From: Mark Warwick
Sent: 19 March 2019 11:48
To: Simon Davis
Cc: Planning.Responses
Subject: Y/98/18/RES

Planning Application Ref: Y/98/18/RES

Location: Land off Burndell Road, Yapton

Description of works: Approval of reserved matters (access, appearance, landscaping, layout and scale) following outline permission Y/19/16/OUT for 108 residential dwellings, with associated parking, road/footway/cycleway provision, open space, landscaping, surface water attenuation and ancillary works

scheme: Burdell Road
Yapton
client: Bovis Homes (Southern Counties)
drawing: Tree Protection Plan
date: November 2018
scale: 1:500@A1
dwg no: BOV22172-03A
drawn: MW checked: TRG

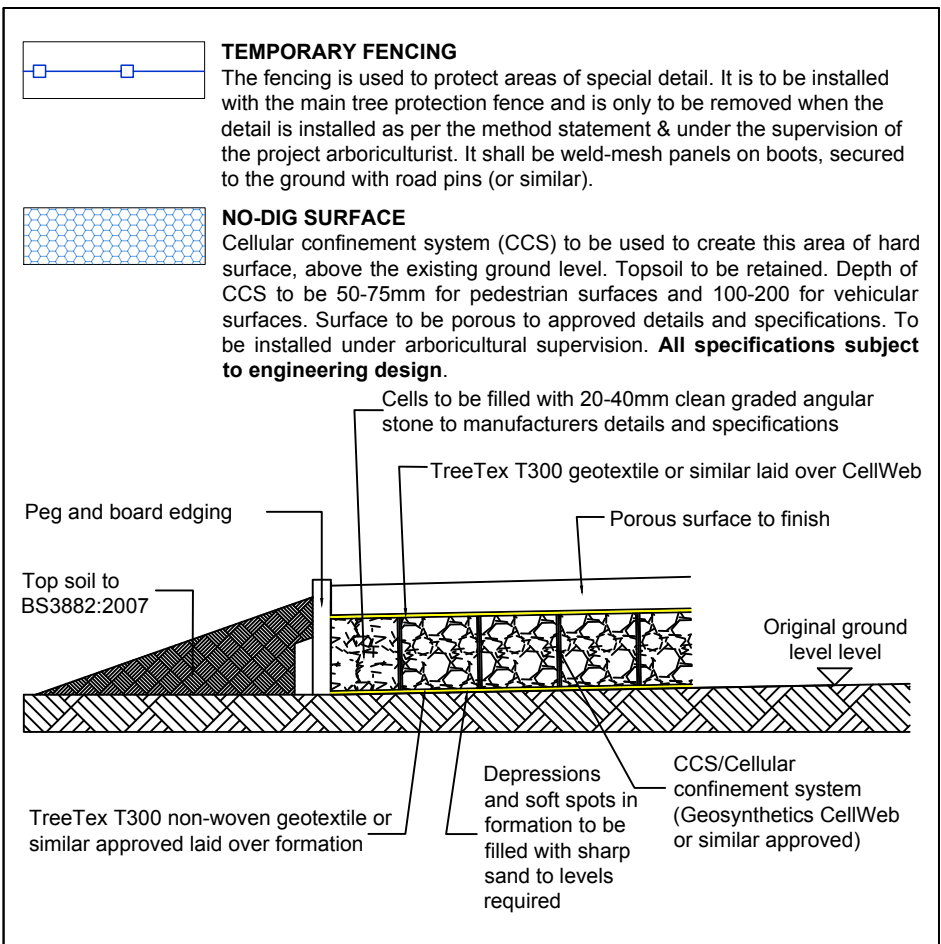
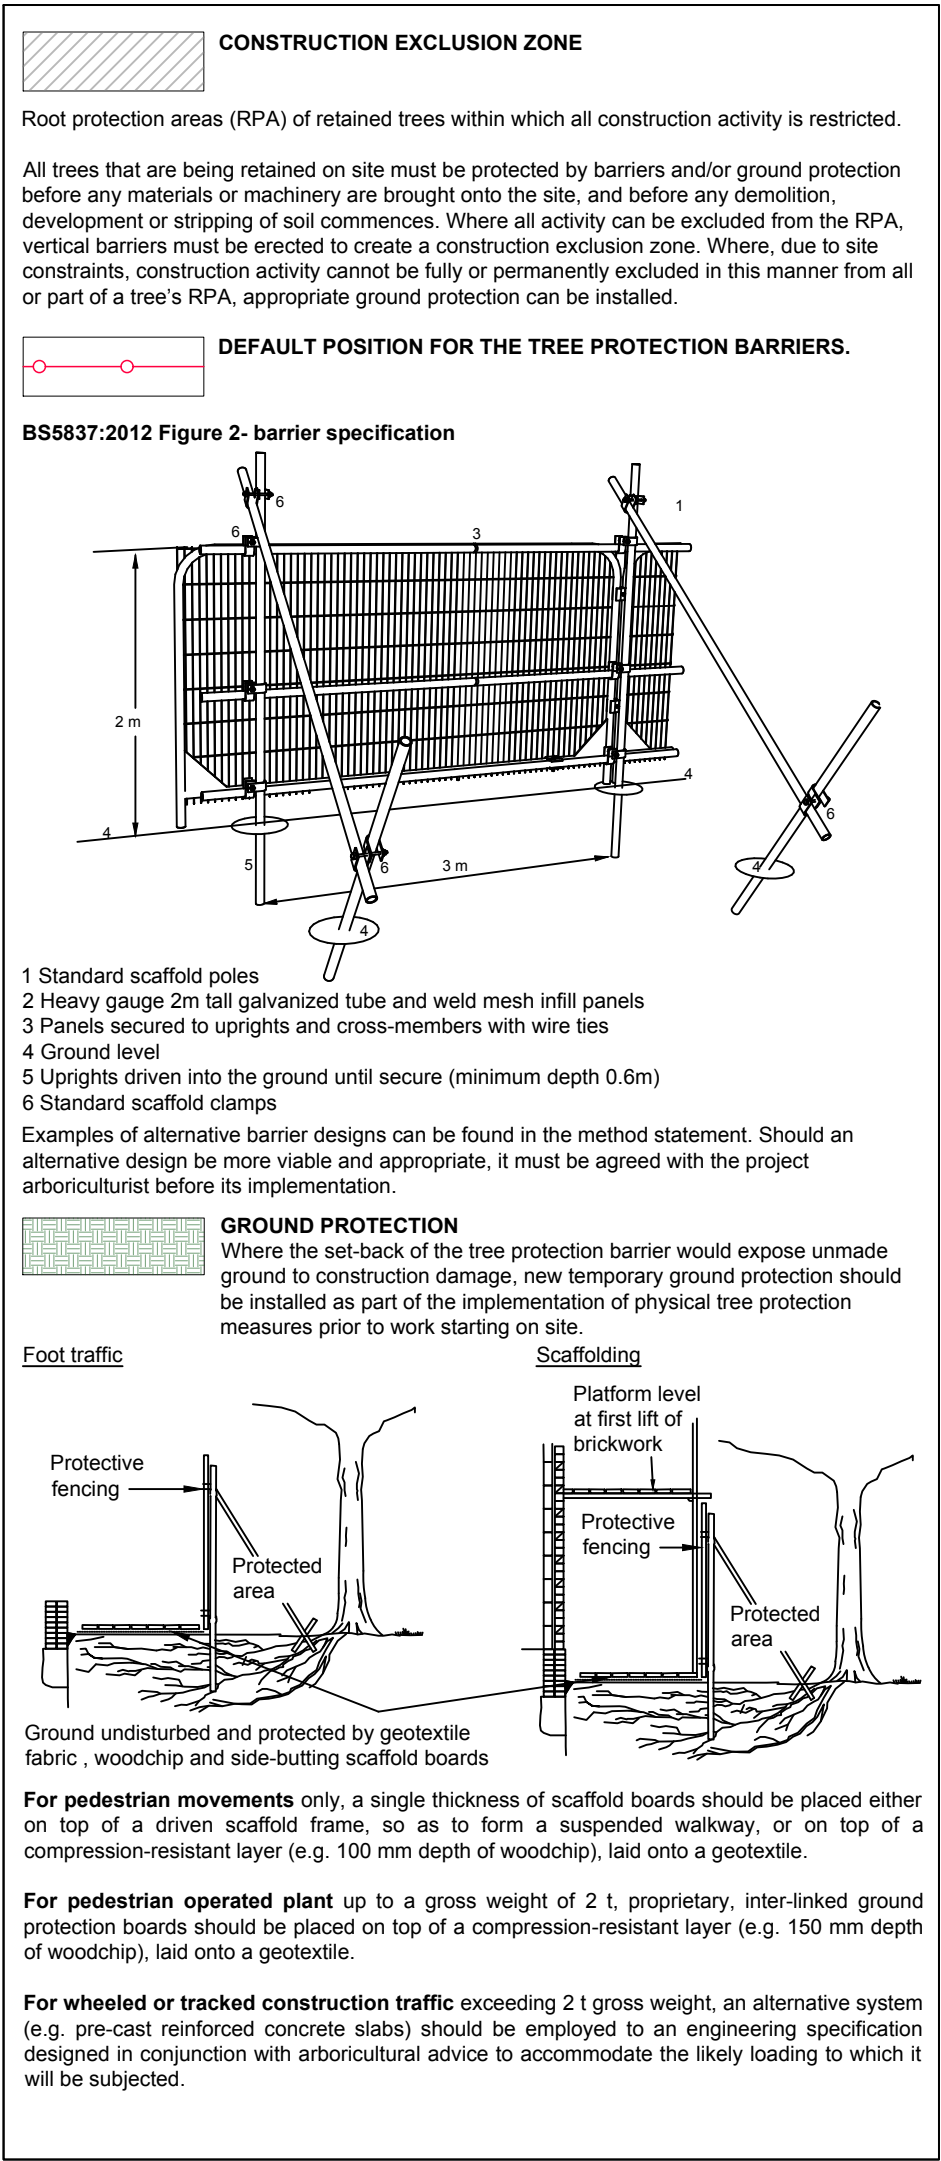
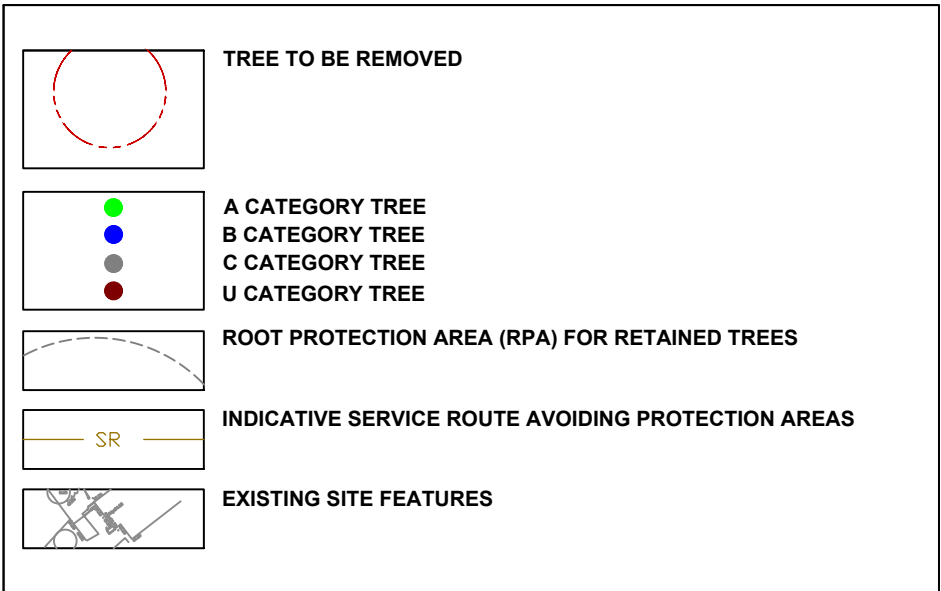
- In support of this reserved matters application, the applicant (Bovis Homes) has employed ACD Environmental to submit a Tree Protection Plan (TPP).
- The TPP shows a typically ambitious layout but with inadequate regard and respect for the few perimeter trees of significant landscape and amenity value.

- The current proposed layout is going to impact on four significant oak trees (G10 and T7) both above and below ground.
- In respect of G10, the proposed attenuation pond intrudes on the root protection area (RPA) of one mature oak, a tree with growth potential and the roots from which will extend beyond the ditchline. This potential conflict is avoidable and should be designed out.

- In respect of T7, significant RPA intrusion is proposed during construction of parking bays. Although achievable in principle by adopting the tree protection measures proposed (No-dig construction); there is nonetheless a risk that attaches during such extensive incursion of root protection areas. This is especially significant where the tree(s) in question are by far the most important locally. This conflict would seem to be easily avoidable by re-locating two of the unallocated/visitor parking bays and so should be designed out.

- The proposed layout carries an avoidable risk of damage to significant trees of high landscape and public amenity value. An alternative layout that better respects those trees appears to be achievable without imposing any significant constraint on the development.
- I anticipate a revised layout being submitted that is more sympathetic to G10 and T7, to which I could lend my support.
